Memorandum

DATE: March 14th, 2014

RE: **Multi-unit Commercial Building**
421 Warren Avenue
PH Warren Avenue, LLC, Applicant
Project #: 2014-016 CBL 296-A006001

Drawing file: Plans / C-2.0 Partial Boundary Survey and Topo Plan by Nadeau Land Surveyors.pdf

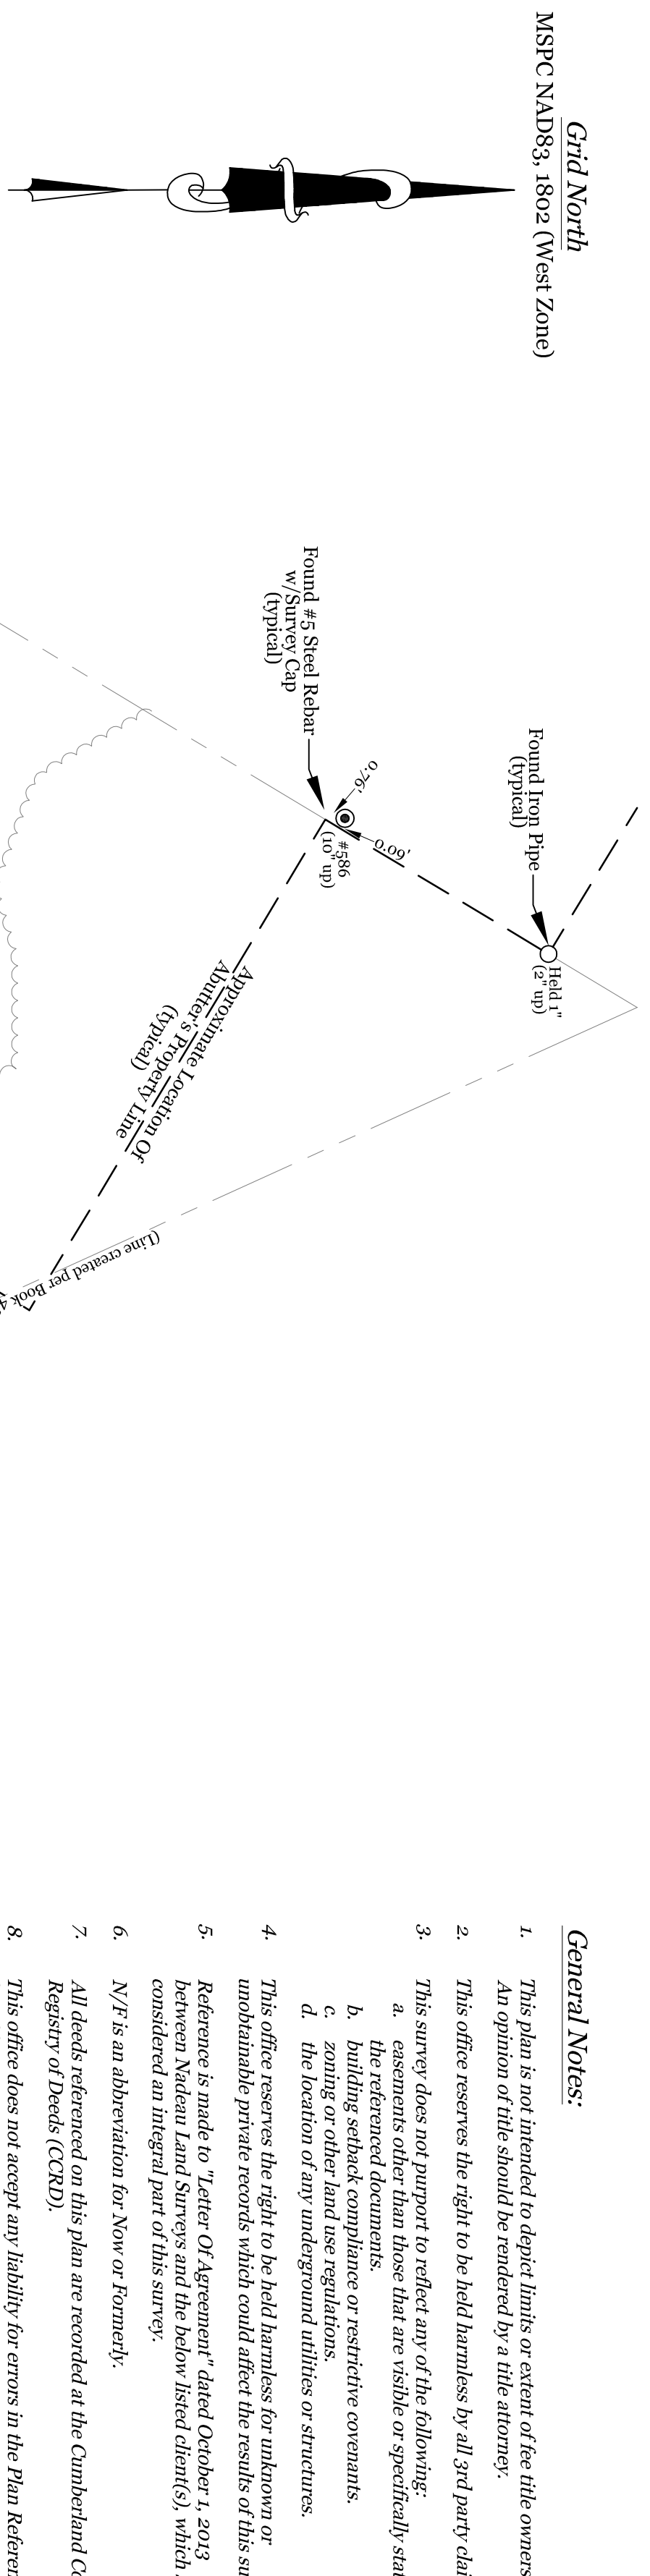
He has also noted that some corrections/amendments are needed to the submitted survey for the site (Plan P2.). An easement for the use of the joint access should be included in the final submission.

DRAWN: CMW DATE: NOVEMBER 2013
DESIGNED: SRB SCALE: 1"=30'
CHECKED: SRB JOB NO. SP-M104
FILE NAME: SP-M104-SITE
SHEET **C-3.0**

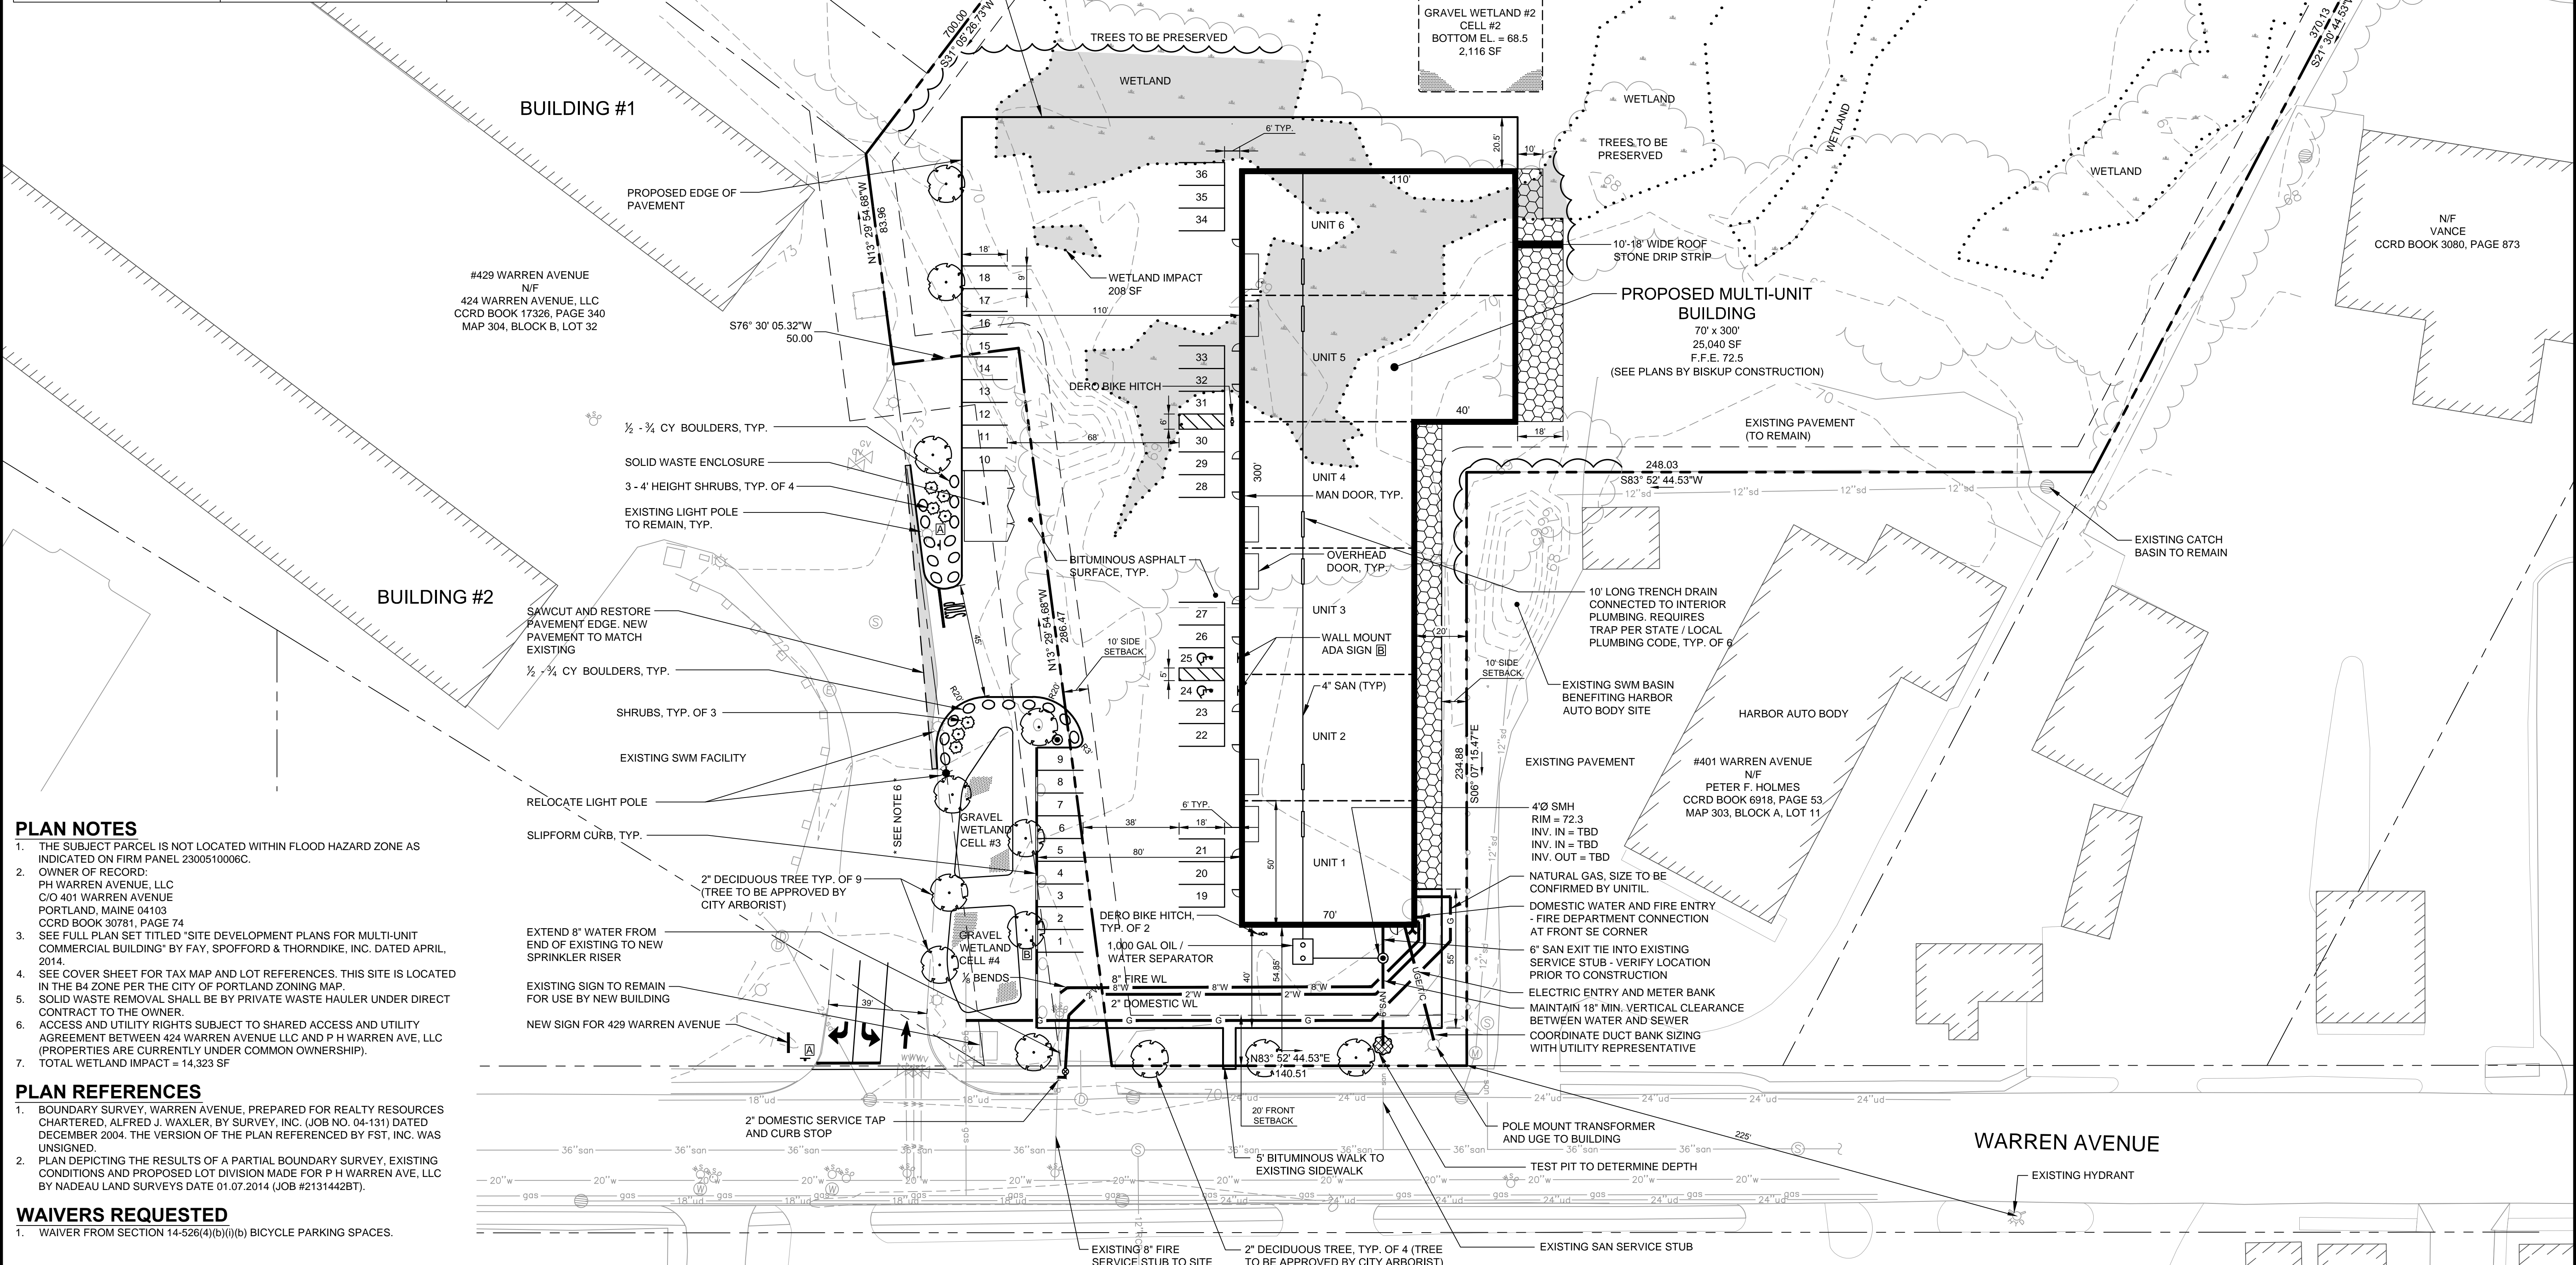
The access into the new site is proposed to be via a 60 foot wide curb cut from the existing access drive from Warren Avenue that currently serves 429 Warren (two existing warehouse /industrial /commercial buildings) (See Plan P6). The 60 foot wide curb cut opens immediately into an area of pavement that extends about 100 feet out from the new building in the central area, narrowing to 80 feet from the new building at the north and south ends and partially wrapping around the building (over 50,000 sq ft in area). This area provides access to the units by large vehicles, including tractor-trailers, and includes parking around the periphery, although it is not clear why the pavement is around the north end when there are no doors at that location (Plan P18).

- a. *The proposed driveway entrance exceeds City standards and a waiver will be required. The applicant shall provide an Auto-Turn analysis documenting the need for the wide driveway.*
- b. *The aisle widths in the internal parking/circulation area do not meet City standards and a waiver will be required. The applicant shall provide an Auto-Turn analysis documenting the need for the expanded pavement areas.*

Each of the proposed 7 units have a pedestrian entrance from the central paved area which also provides parking spaces (Plan P6). Although the south end of the building is about 50 feet from the existing Warren Avenue sidewalk, the current proposals do not include any pedestrian link from the sidewalk to the building entrances. The Site Plan Ordinance includes a standard that states (14-526 (a) 2. c. (iii):

- *A sidewalk connection from the proposed building to Warren Avenue shall be provided.*
- *An area along the building frontage on the parking area shall be marked such that pedestrians have a direct routing to Warren Avenue.*

The site plan (Plan P6.) does not specifically call out snow storage. The proposed paved area is likely to provide adequate area for snow storage, but the proposed wetland cells, swales and erosion control features about the paved area and a Snow Storage Plan is required to ensure that these areas are not used for snow storage.

The Site Plan (Plan P.6) shows three street trees and a few shrubs and boulders near the new access from the joint drive. The Site Plan requirements for parking areas also apply to the B4 zone and additional planting/replacement planting is required to meet this standard, particularly in view of the likely impact on the existing trees in the northern part of the site. (Attachment 4)

The proposed lighting fixtures are included in Attachment E (at end) and the Photometric Plan is included in Plan P7; both meet the City's Technical Standards. There are two existing lights (Plan P6) shown near the site entrance and details of these lights should be submitted as part of the final submissions to ensure these also meet Technical Standards.
